City of Portland, Maine - Building or Use Permit

Permit No: 04-0701	Date Applied For: 06/01/2004	CBL: 335 G001001
------------------------------	--	----------------------------

Proposed Use: Single Family w/deck after the fact	Proposed Project Description: 15' x 12' deck and re-build existing steps
---	--

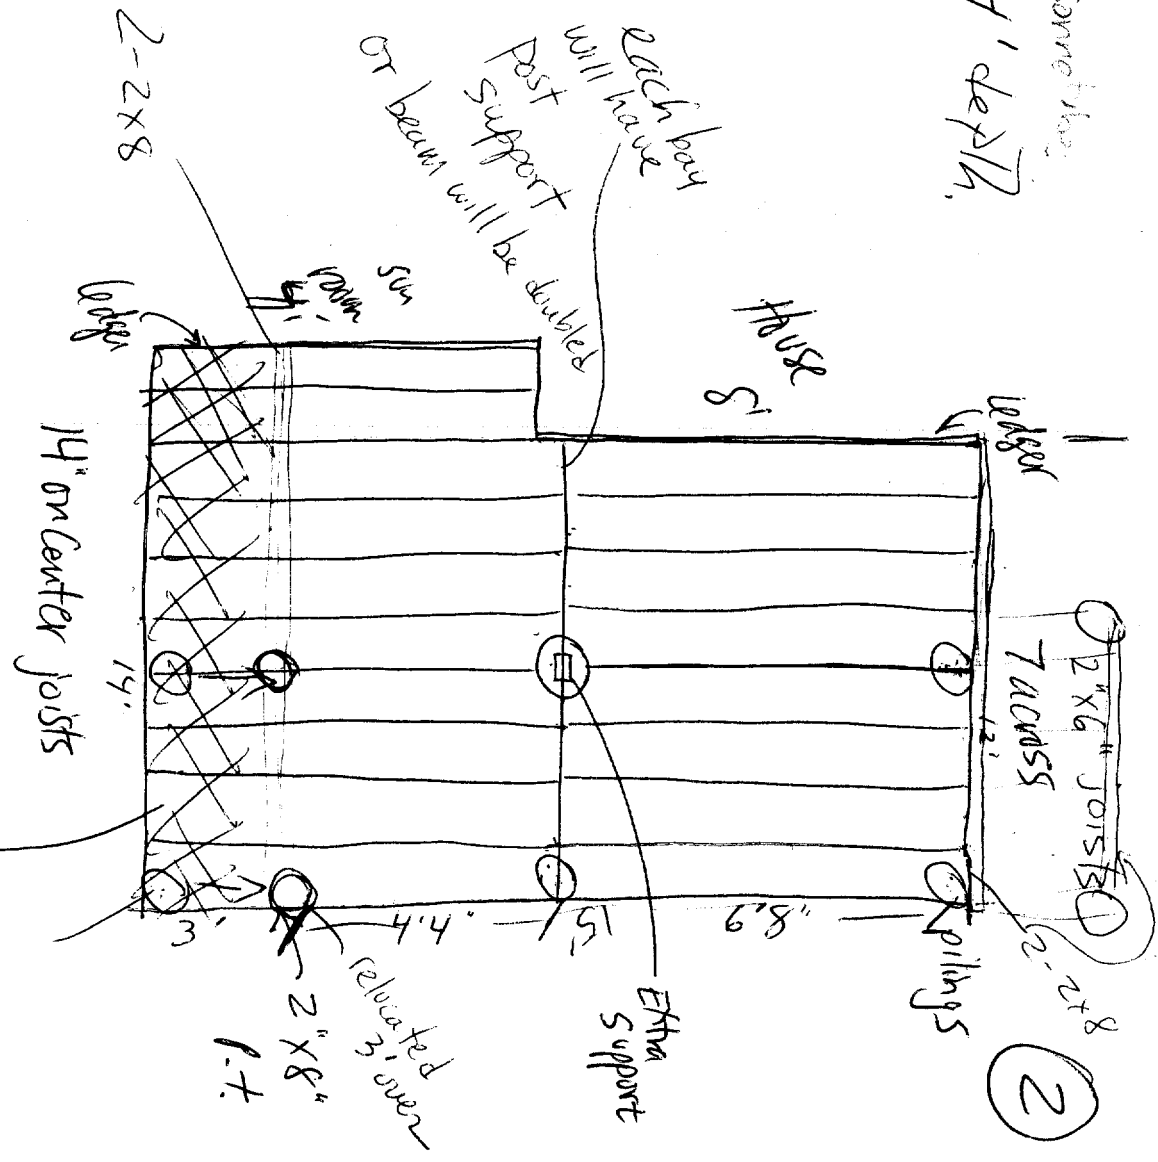
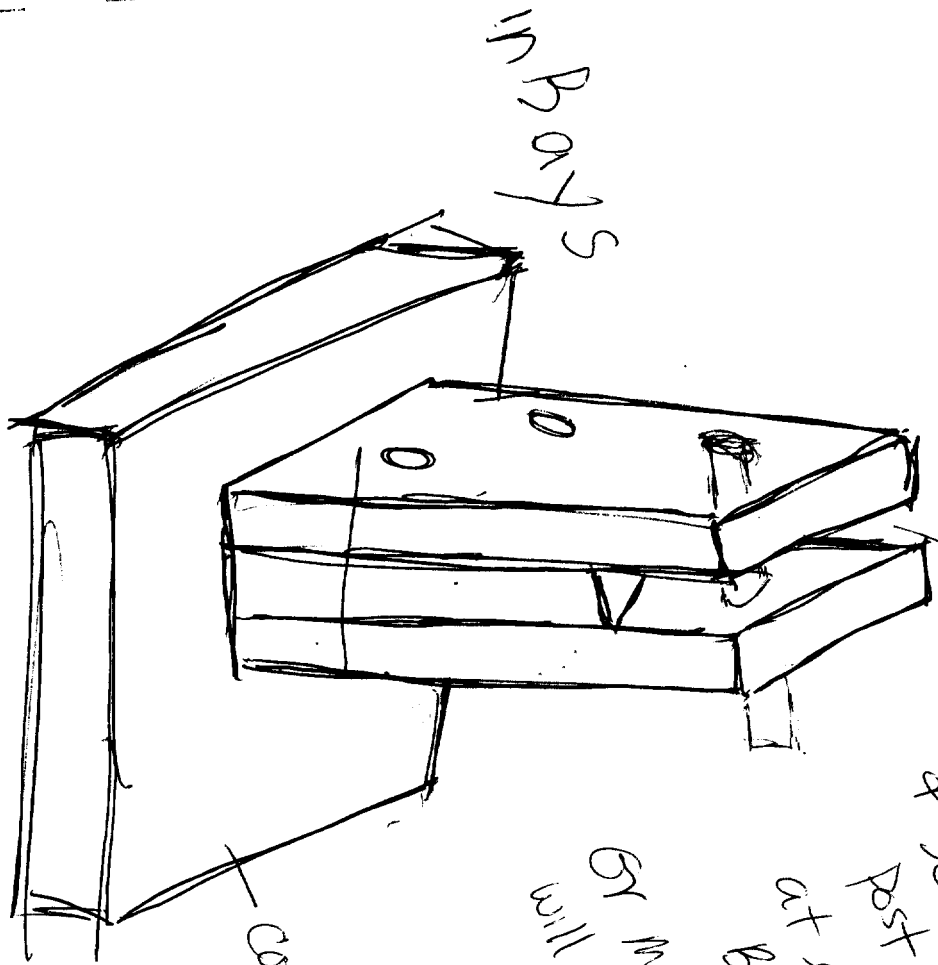
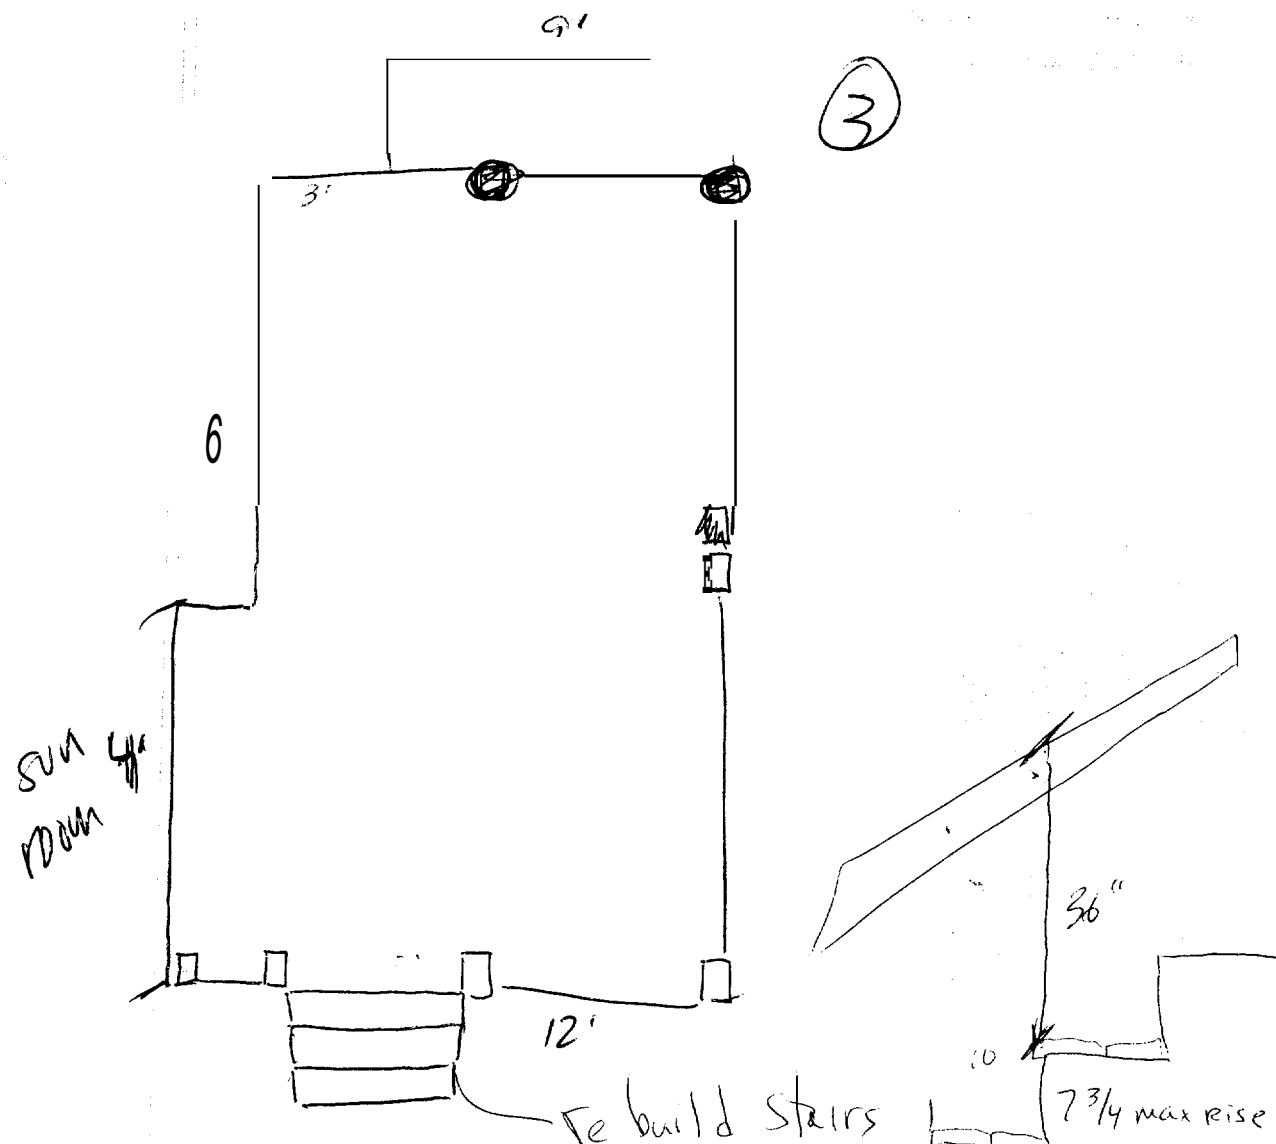
remove 3' To meet setback

36" handrail
 30" from ground
 12' lengths decking 5/4"

36"
 10" min Run string cut 10"
 7 3/4" max rise

< 4" space on balusters

Graspable H-Rail on one side
 34"-38" w/returned ends

ADDRESS: 167 Harris Avenue, Portland, Maine

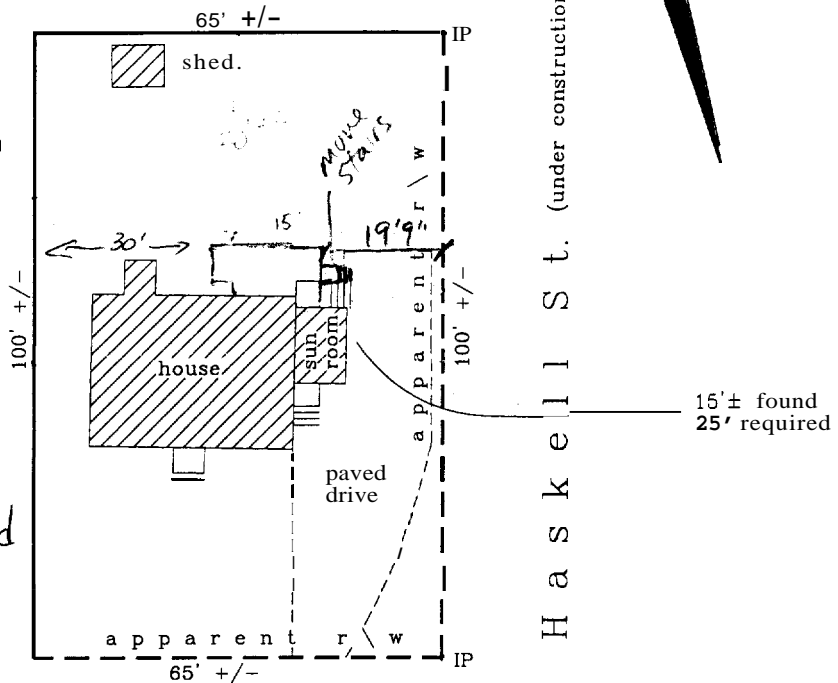
- 1) This permit is being issued after the fact and approximately 3' will be removed from the driveway side in order to achieve the required setback.
- 2) This permit is approved using Sec. 14-433 for a reduction in the side yard on a side street setback based on safety of exiting the building at the sliding door. This reduction should put the deck at no less than 19'-6" from that side setback.
